Our reference: ECM: 8965012
Contact: Gavin Cherry
Telephone: 4732 8125

28 January 2020

SSD 7348 - MOD 2 - Further Amendments to Concept Plan and Stage 1, Oakdale West Precinct

01 Northern Carpark - Entry Marker  
Detail Plan - Scale 1:200 @ A1

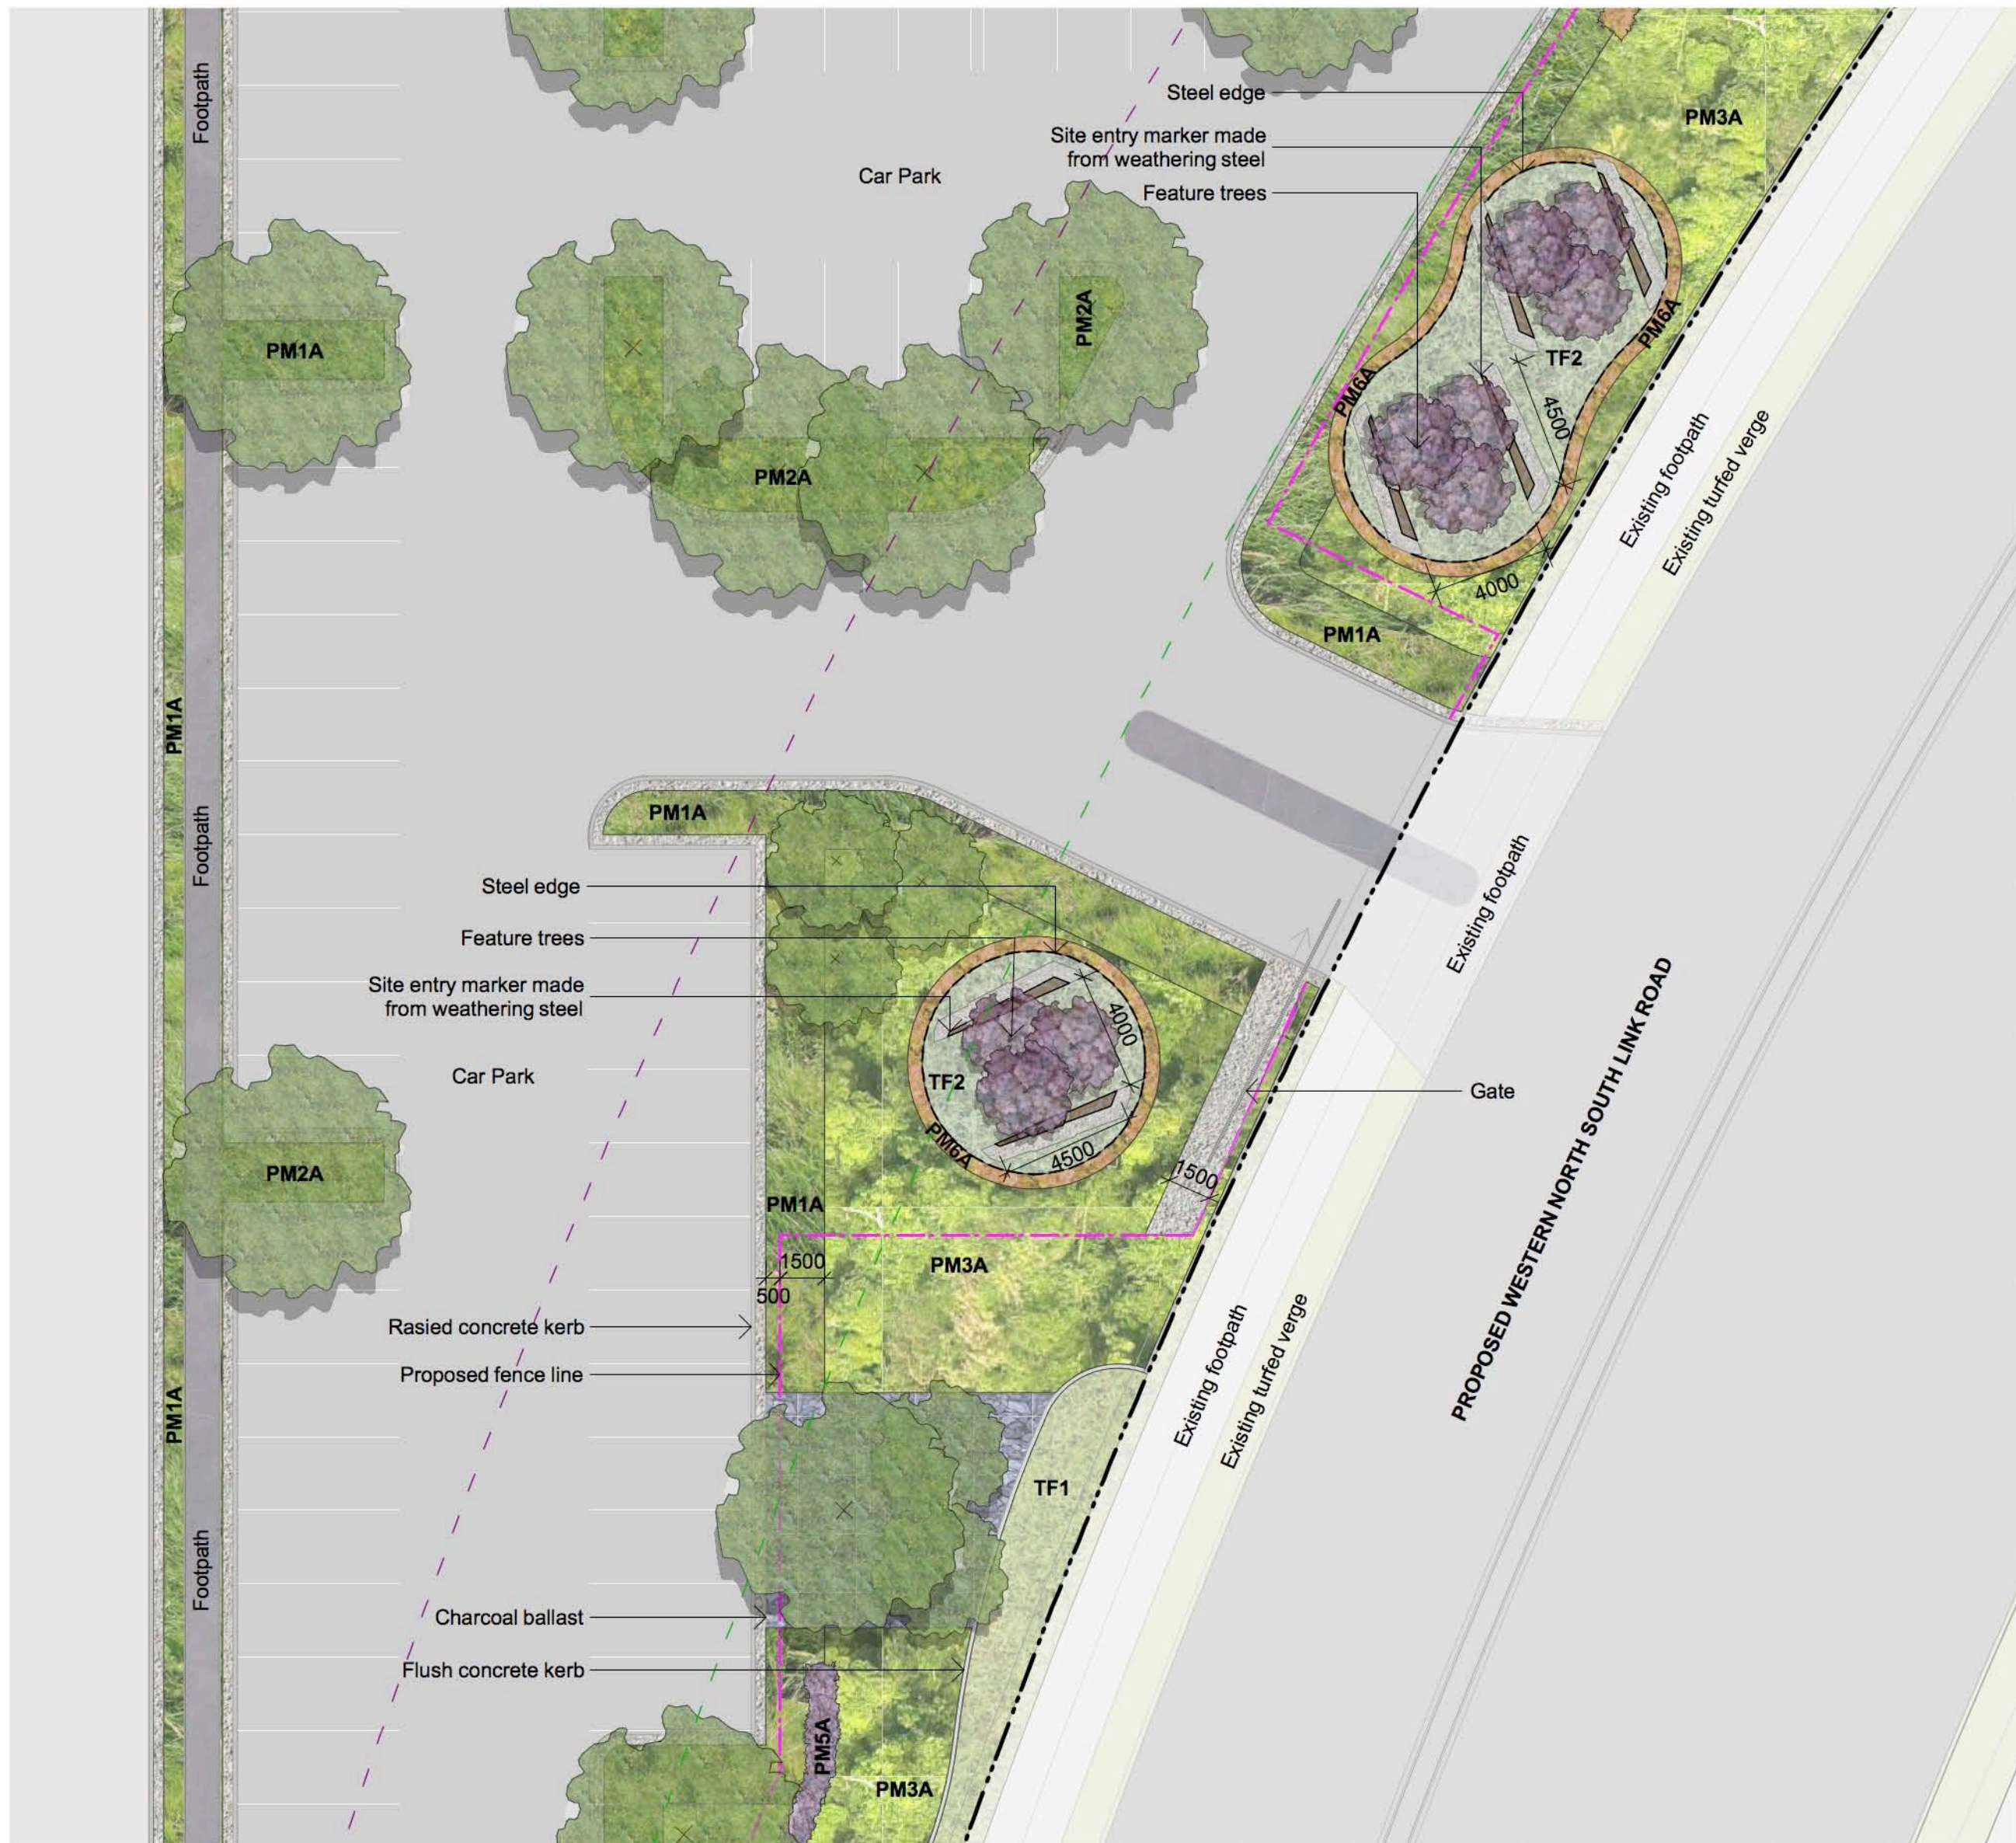
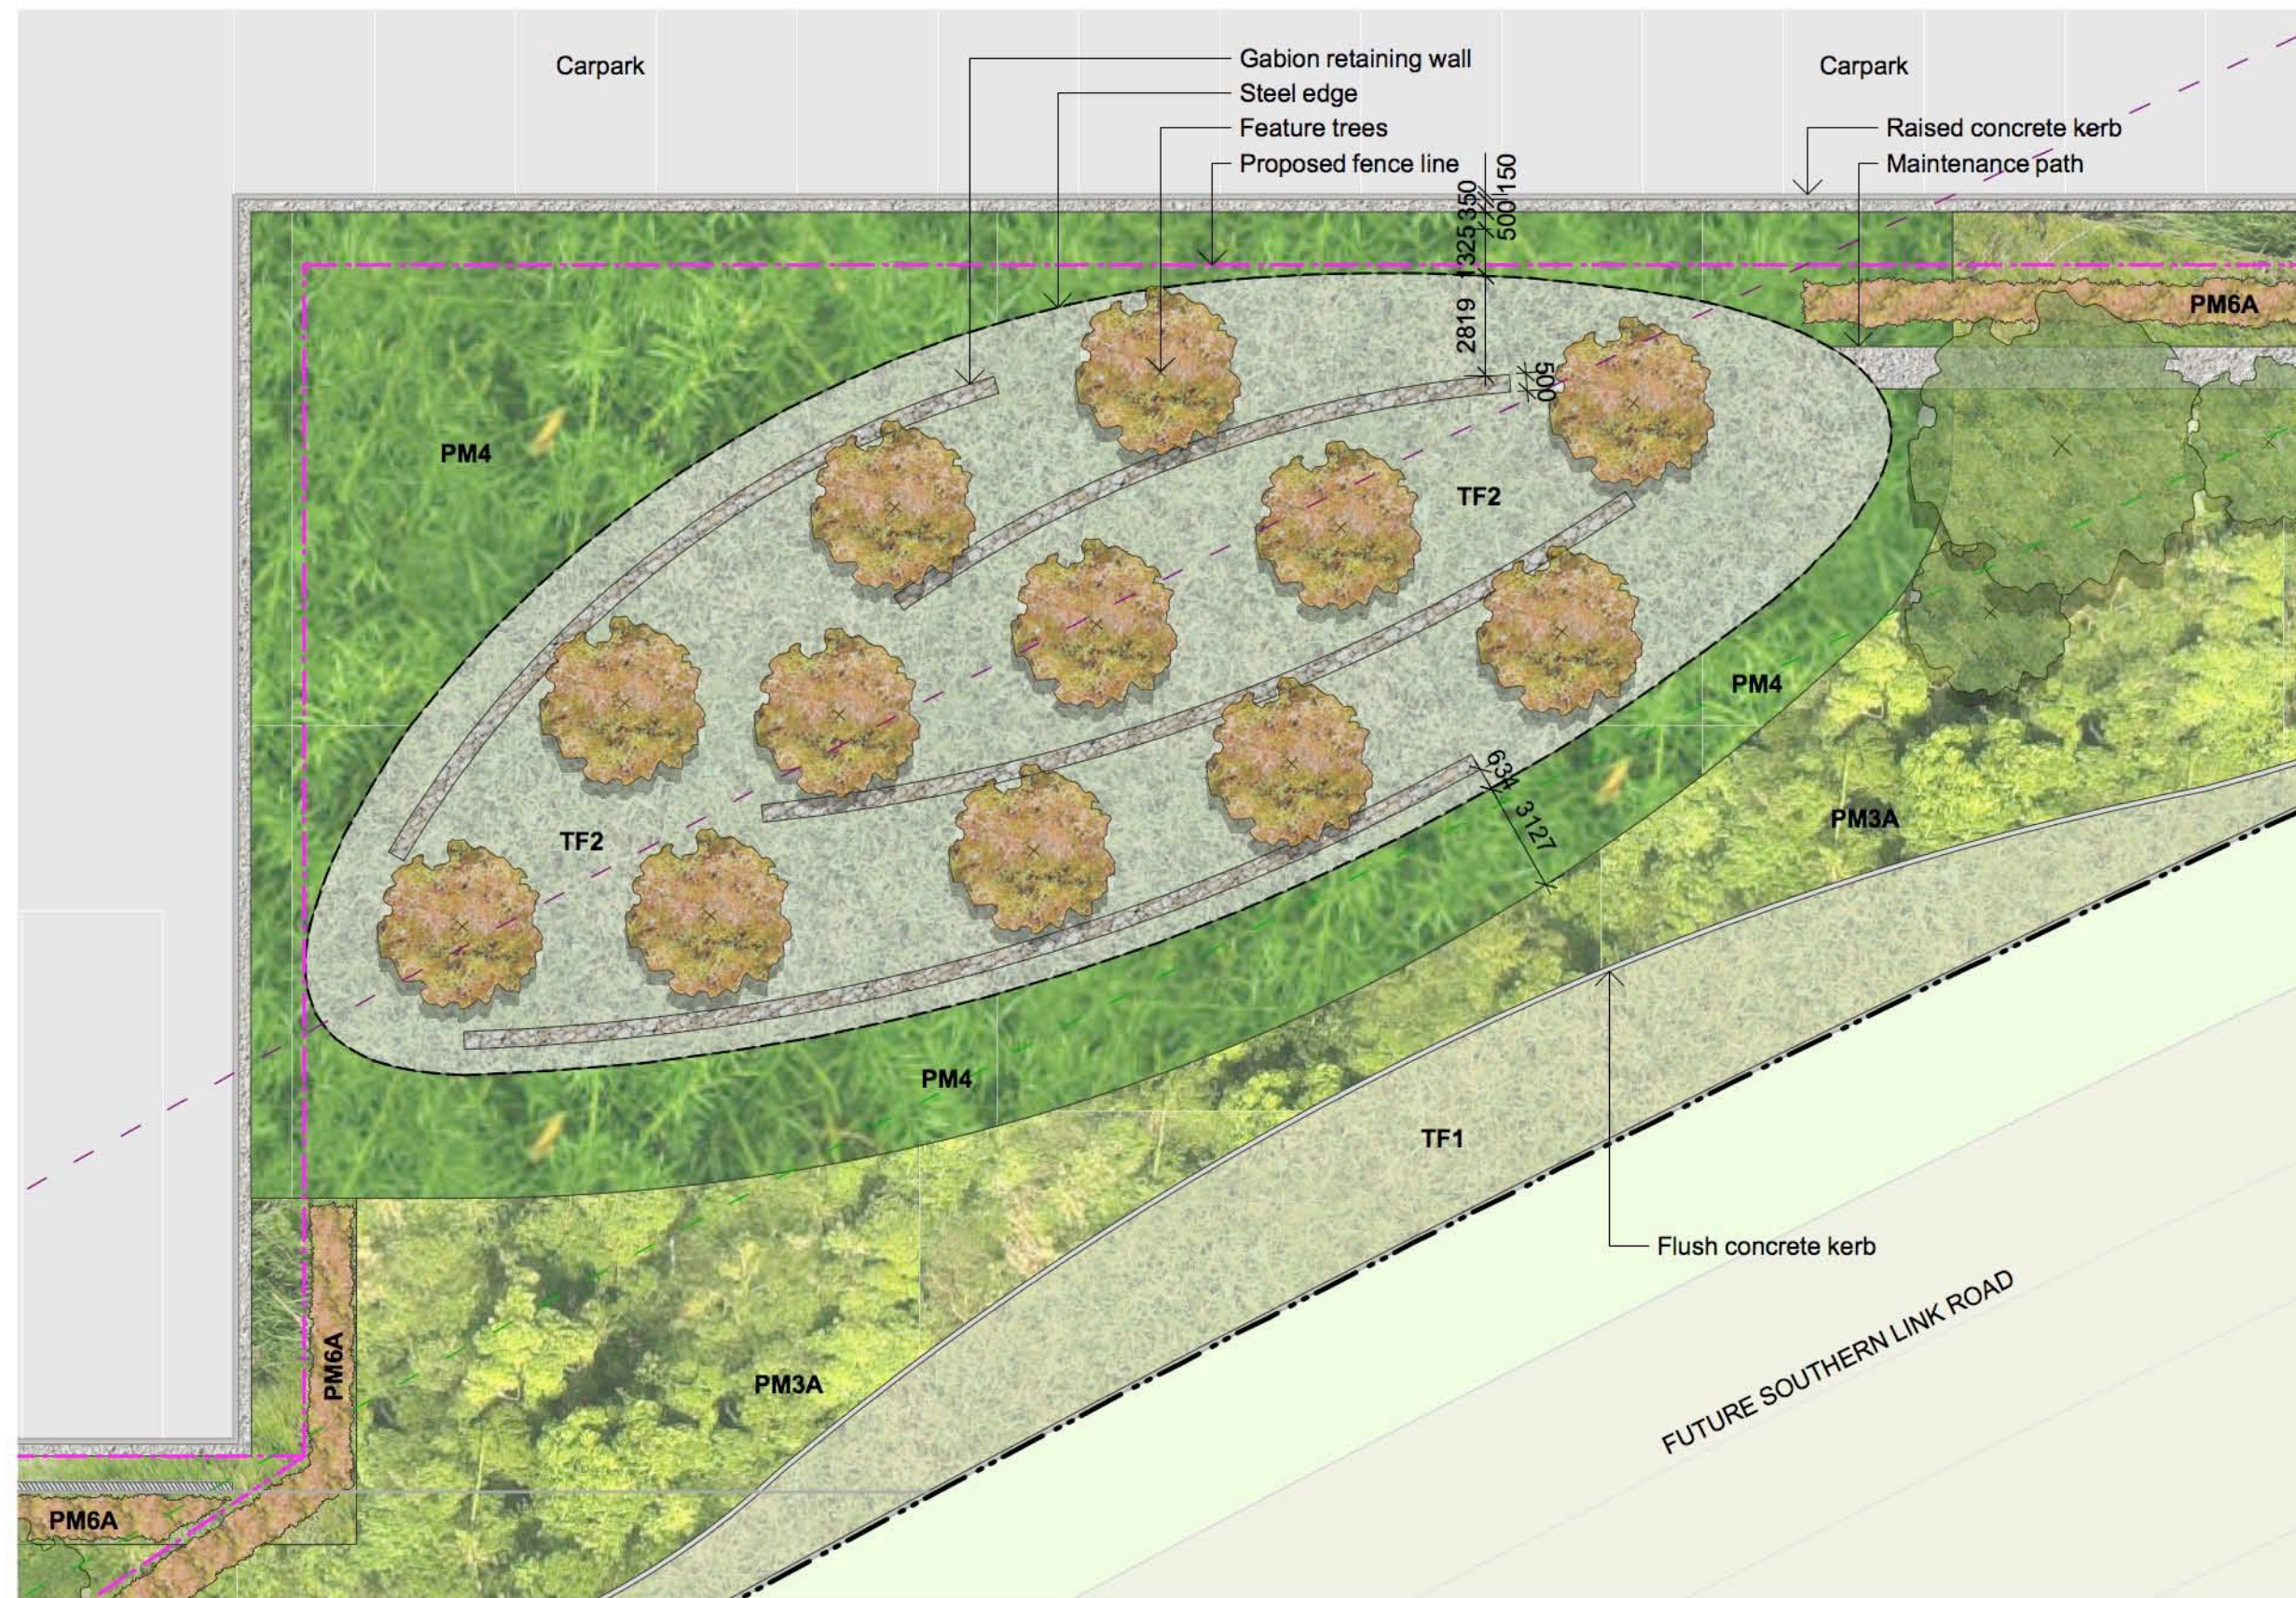
Chapter C9 – Advertising and Signage of Penrith Development Control Plan 2014 specifically limits advertising pylon signage structures to no greater than 7.0m in height. The proposal provides pylon signs of 4.05m in width and 12m in height. This is an excessive scale of signage and is contrary to the objectives of the DCP. Smaller signage can still achieve sufficient site identification and way finding with typical pylons dimensions being maximum 2.0m width and 7m height. The majority of the signage indicated on the pylon signage plan is estate branding which can be contained within the 2.0m width underneath the Goodman Logo.

The dimensions and size of the proposed pylon structures represent a dominant element in the streetscape and it is recommended that this be revised or addressed as a condition of consent.

In addition, sign wall type S8 may not be located within the boundaries of the site, and there are no details provided regarding dimensions, lighting and the like. Signage must be contained within the boundaries of the site (not within the road reserve) and dimensions, lighting, colours and finishes should be confirmed where not already detailed on the signage plans.
